From: Simon Davis
Sent: 12 July 2021 18:27
To: Daniel Medrow [REDACTED]
Subject: RE: Vistry Yapton - Y/72/21/DOC - Y/19/16/OUT

Our Director has stated that a pumped option should always be one of a last resort so you need to provide details of the other options so we can judge what there are, any potential harm and then come to a considered view. It is acknowledged that you have supplied full details of the first option (regrading of both the sewer system and highway) and so it is the third option (ditch regrade) that we need more detail on.

Reference	Location	Proposal	Status
Y/72/21/DOC	Land off Burndell Road Yapton BN18 0GG	Approval of details reserved by condition imposed under ref APP/C3810/V/16/3158261 (Y/19/16/OUT) relating to Condition No 5 - surface water drainage	Undecided

APPENDIX D – Extent of Ditch Regrading 18-070/232A

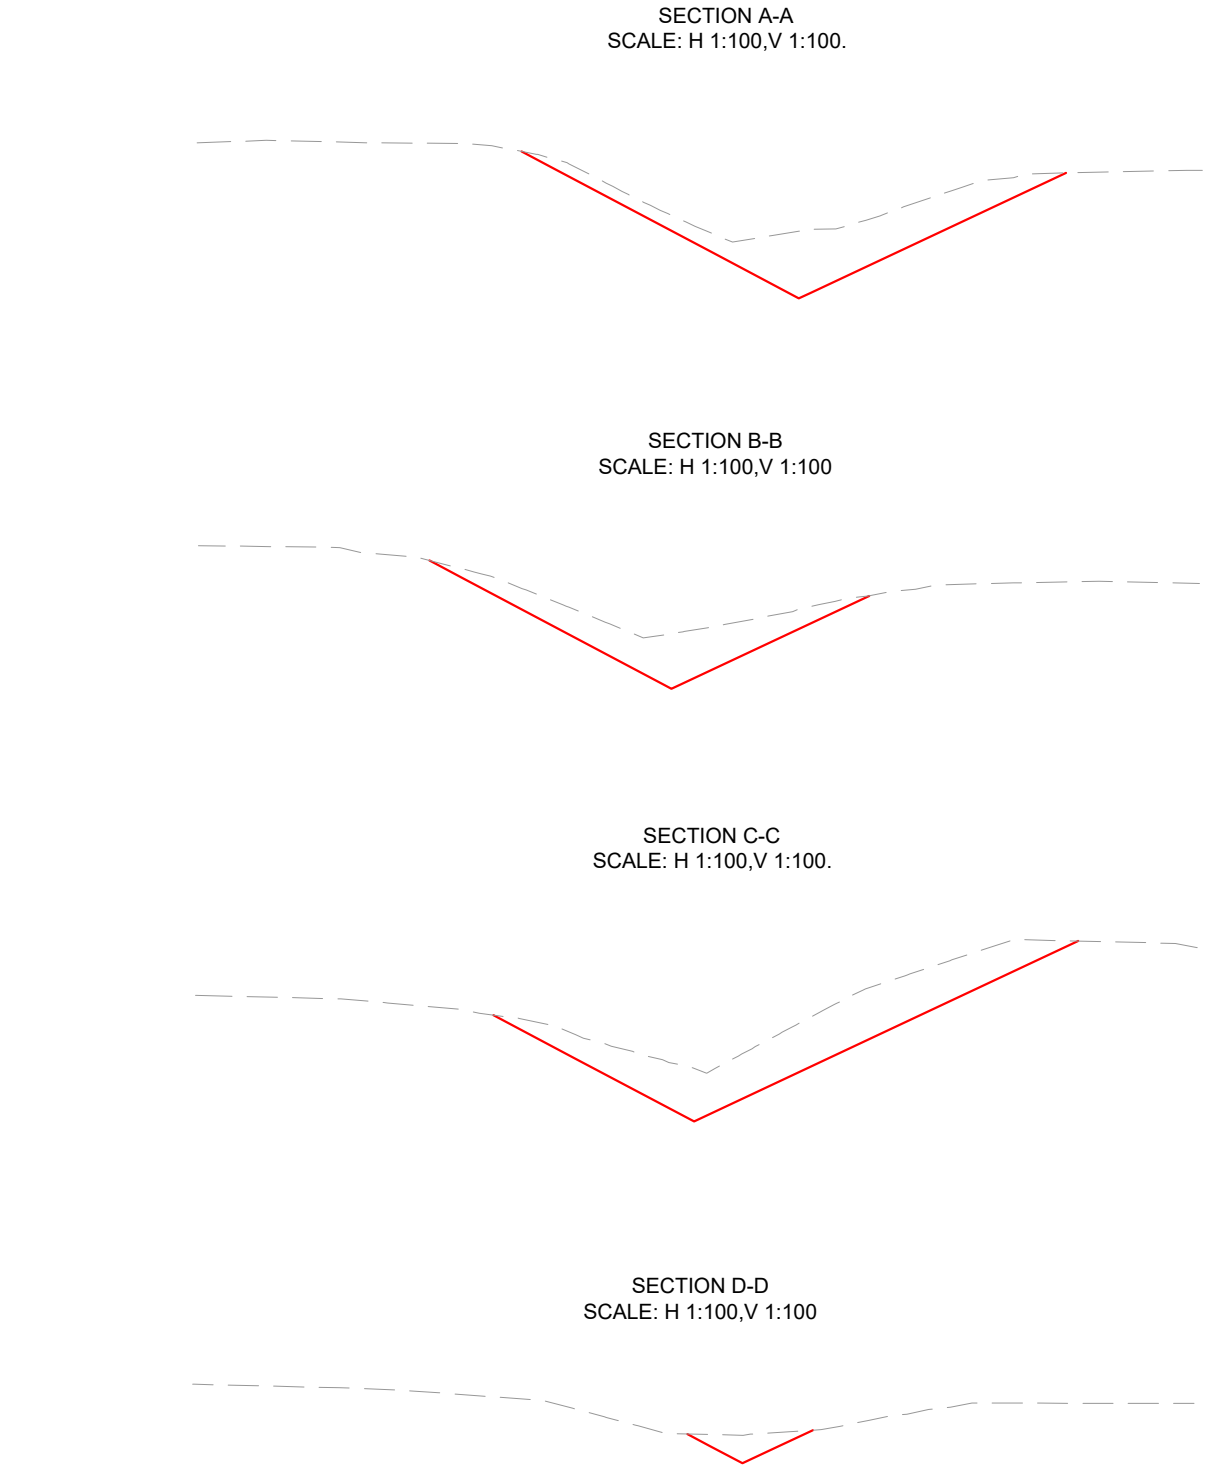
I therefore write to request that you provide a survey based plan to show what changes would be required to the ditch to achieve the necessary levels. Should this require land from the Crayfern site then I would suggest that this be annotated clearly/shaded as based on the built Crayfern layout to show what the impact would be on that site. I also suggest that you should have the impact on trees and ecology assessed so we can be clear what the overall harm would be from this option. Simply stating that there is potential for harm is not sufficient.
